DECISION DELEGATED TO HEAD OF PLANNING

Application No: H05-0294-23 **Applicant:** Mr A Wright
Proposal: Proposed dwelling & detached garage
Location: Adj. 14 Cross Street Fleet Spalding
Terminal Date: 9th June 2023

Proposed Block Plan (1:250)

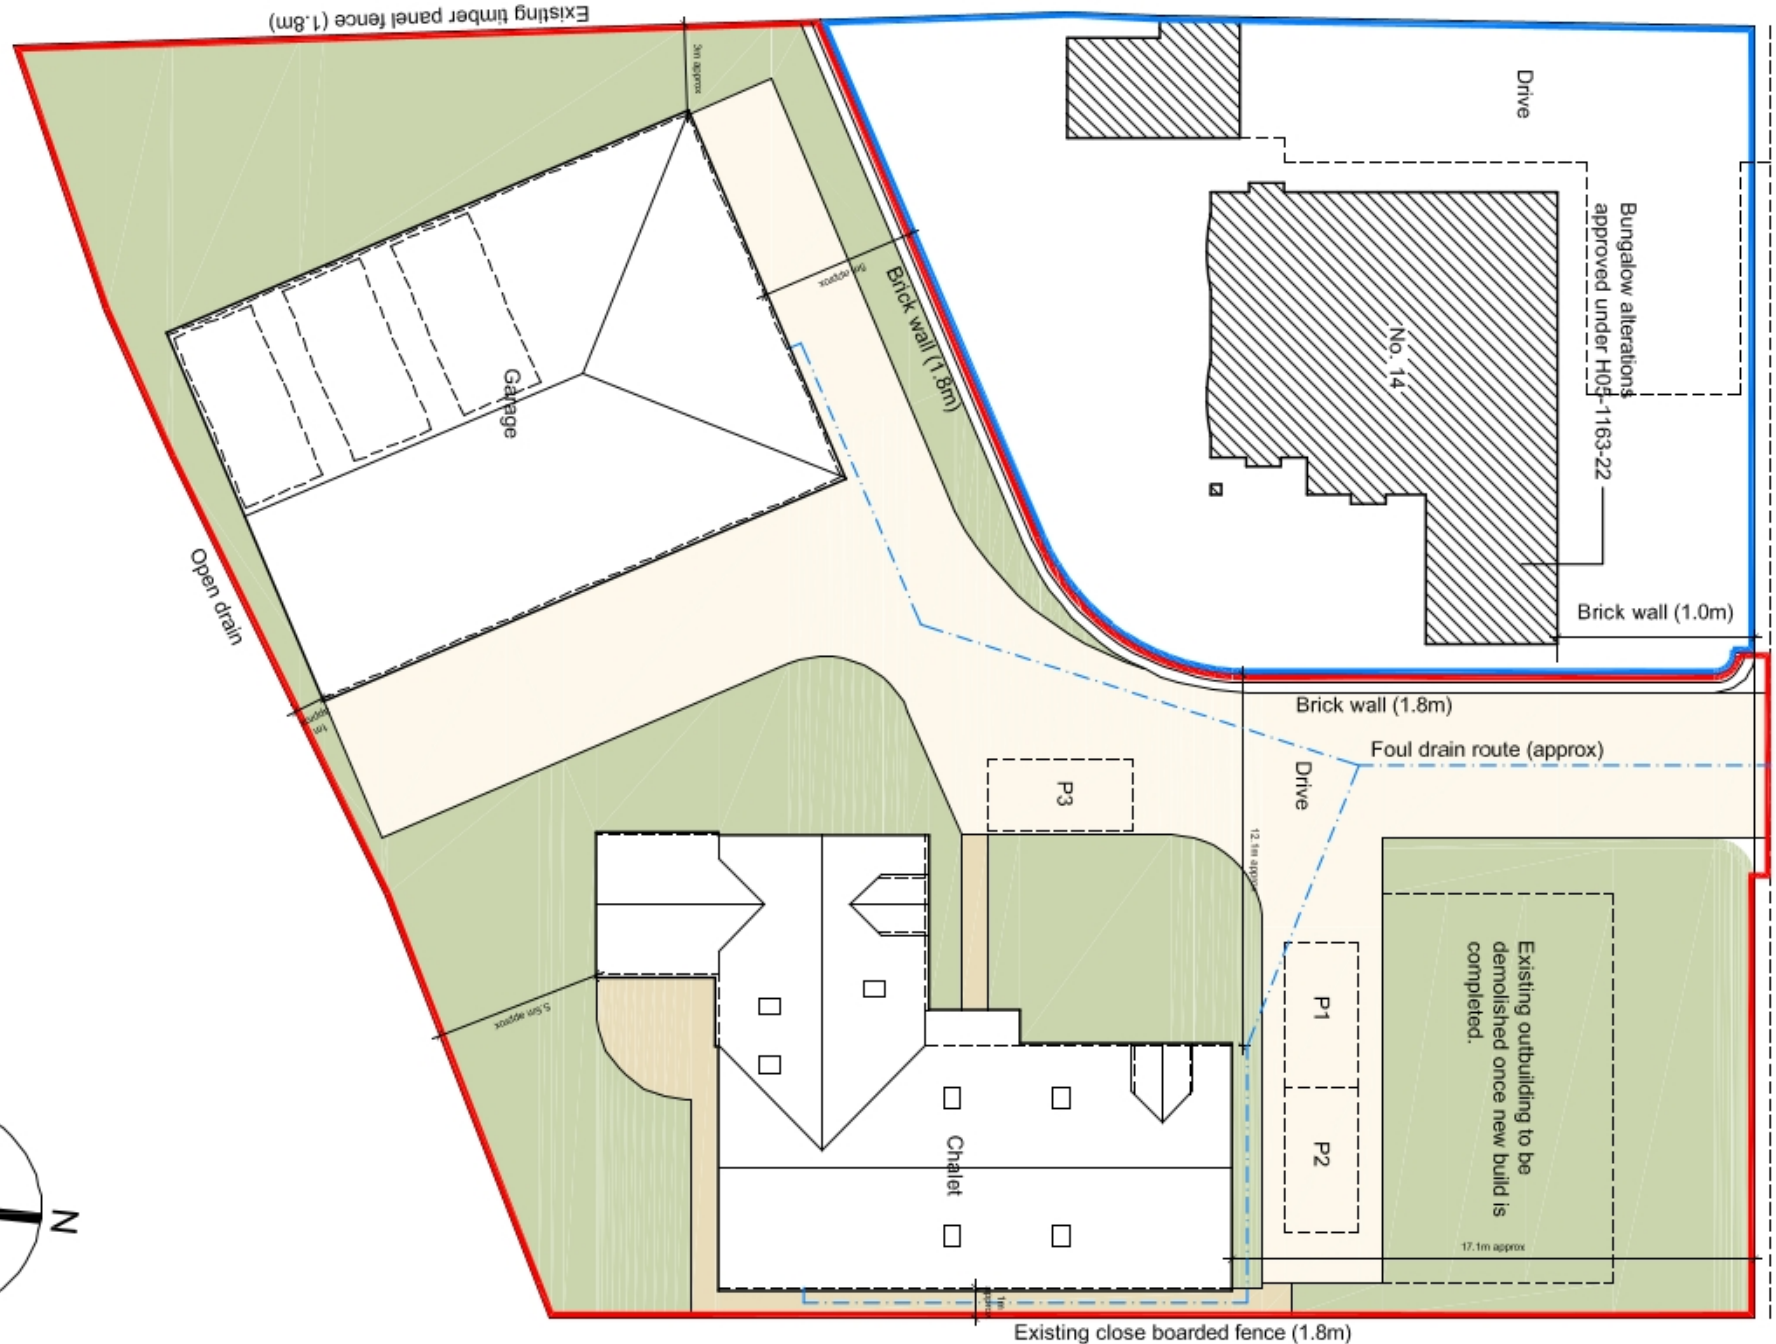
The originally submitted plans have been amended with the height of the garage reduced from 6.6 metres to 6.2 metres and the roof hipped on the northern side. However, unfortunately the proposals are still considered unacceptable as the scheme results in overdevelopment of the site and constitutes a cramped and inappropriate form of development that would be out of character with the area. In addition the way the site is being split is out of character with the rest of the street and would result in an odd shaped plot.

The proposal would result in a much smaller plot for no.14 which is out of character with the prevailing density of the area and to the detriment of the existing character and appearance of the area and would leave very little outdoor amenity space for no.14.

The closest neighbour to the proposed development is no.18 Cross Street located to the east of the application site. The proposed dwelling would be sited close to the shared boundary with this neighbour. Given this, the footprint and height of the proposed dwelling, the relationship with this neighbour and the orientation of the property the proposed development would result in overbearing impact and unacceptable overshadowing on no.18.

In respect of the existing dwelling at no.14 Cross Street located to the north/north-west of the proposed dwelling the development is considered to result in an unacceptable relationship and noise and disturbance on the occupants of this dwelling due to the increased noise from vehicles

using the proposed driveway which would run across the whole of this neighbour's eastern and southern boundaries.

Drawing Title			
Plans, Elevations & Section (Garage)			
Client			
Mr Adrian Wright			
Drawing Title

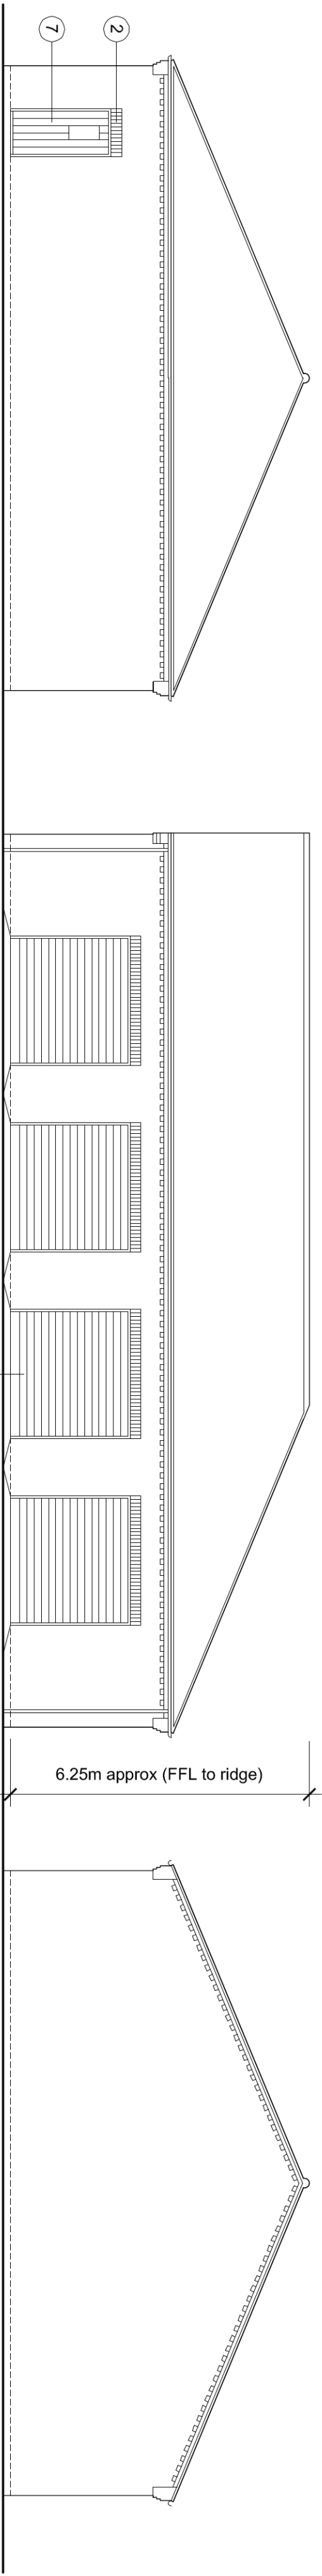
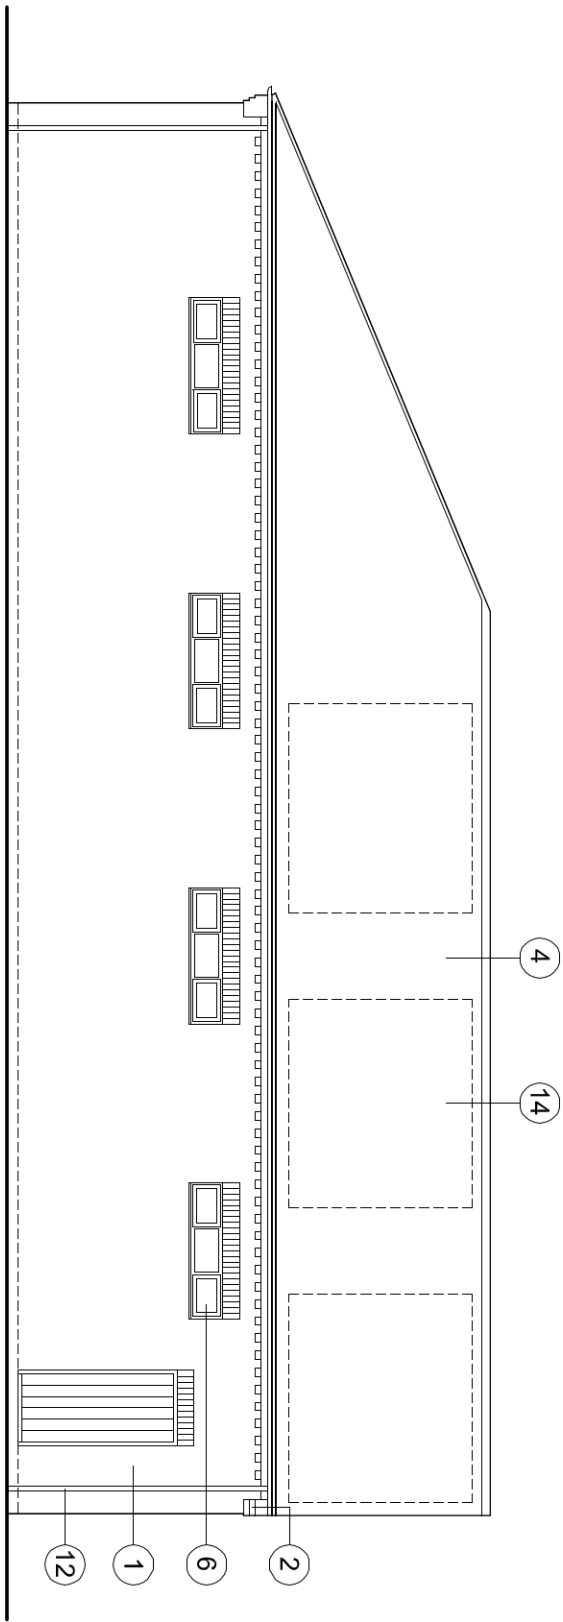
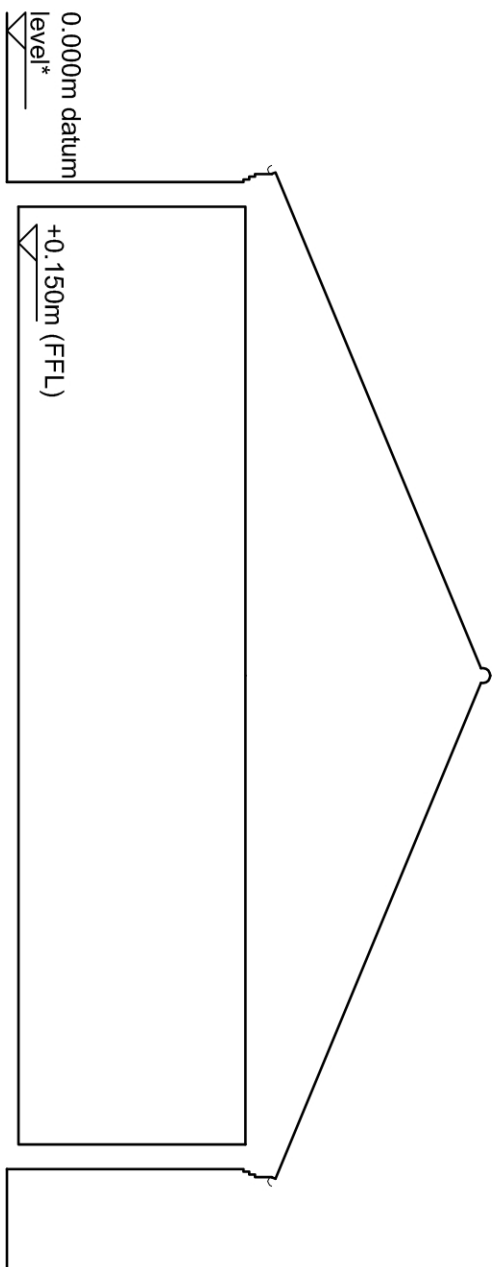
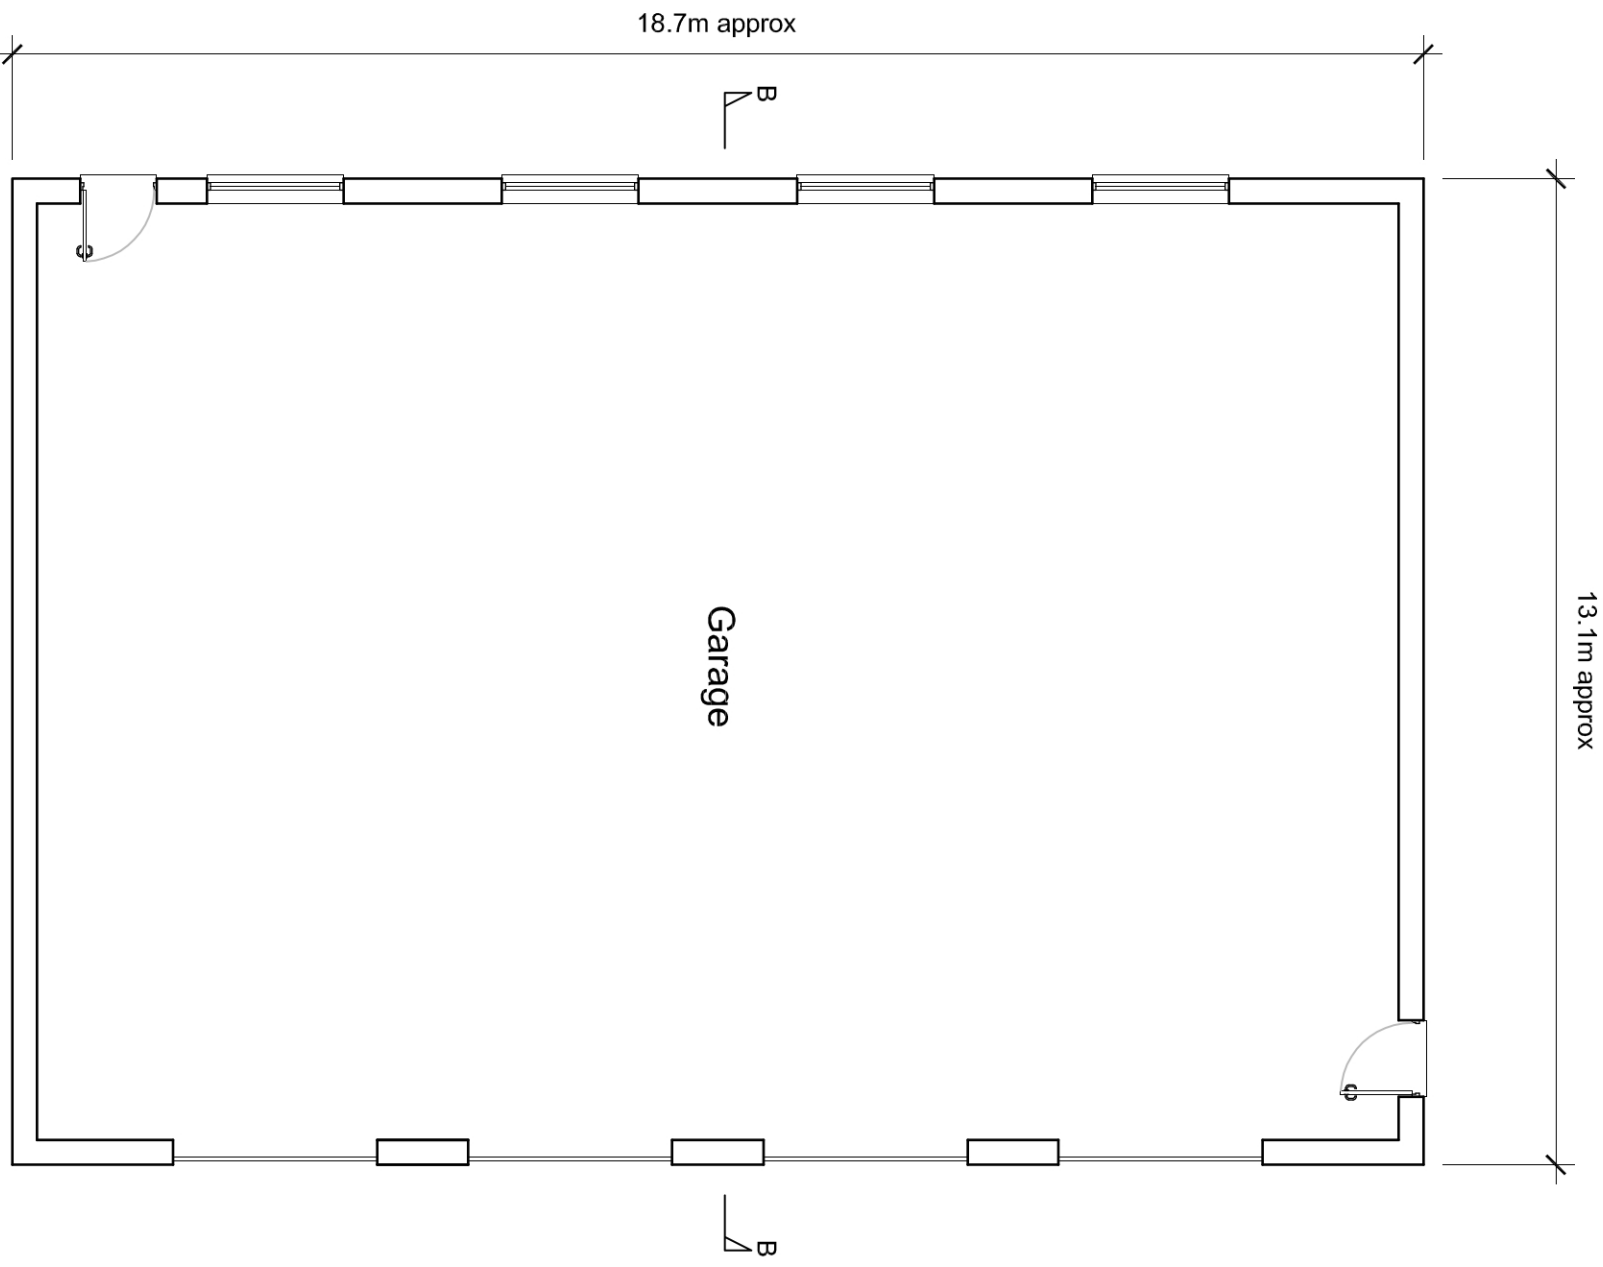
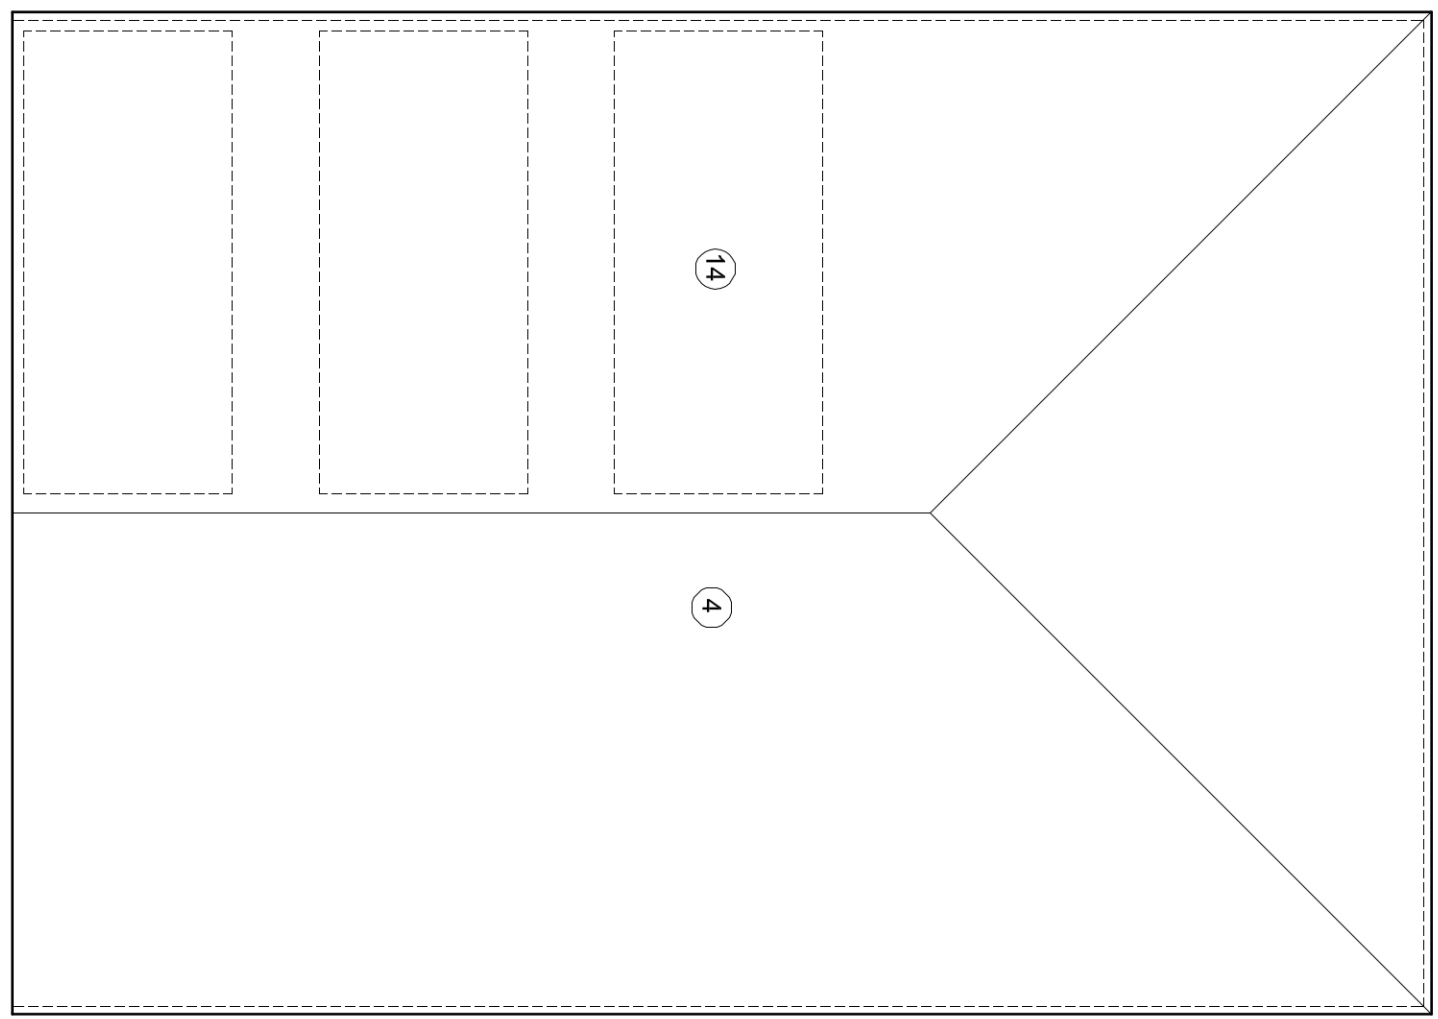
The originally submitted plans have been amended with the height of the garage reduced from 6.6 metres to 6.2 metres and the roof hopped on the northern side.

With regards to the neighbour to the west of the site at no.12A Cross Street the proposed garage would be sited close to the shared boundary with this neighbour. However, given the relationship with this neighbour and the fact the pitch of the garage would face away from this neighbour the impact on this neighbour would be within acceptable tolerances.
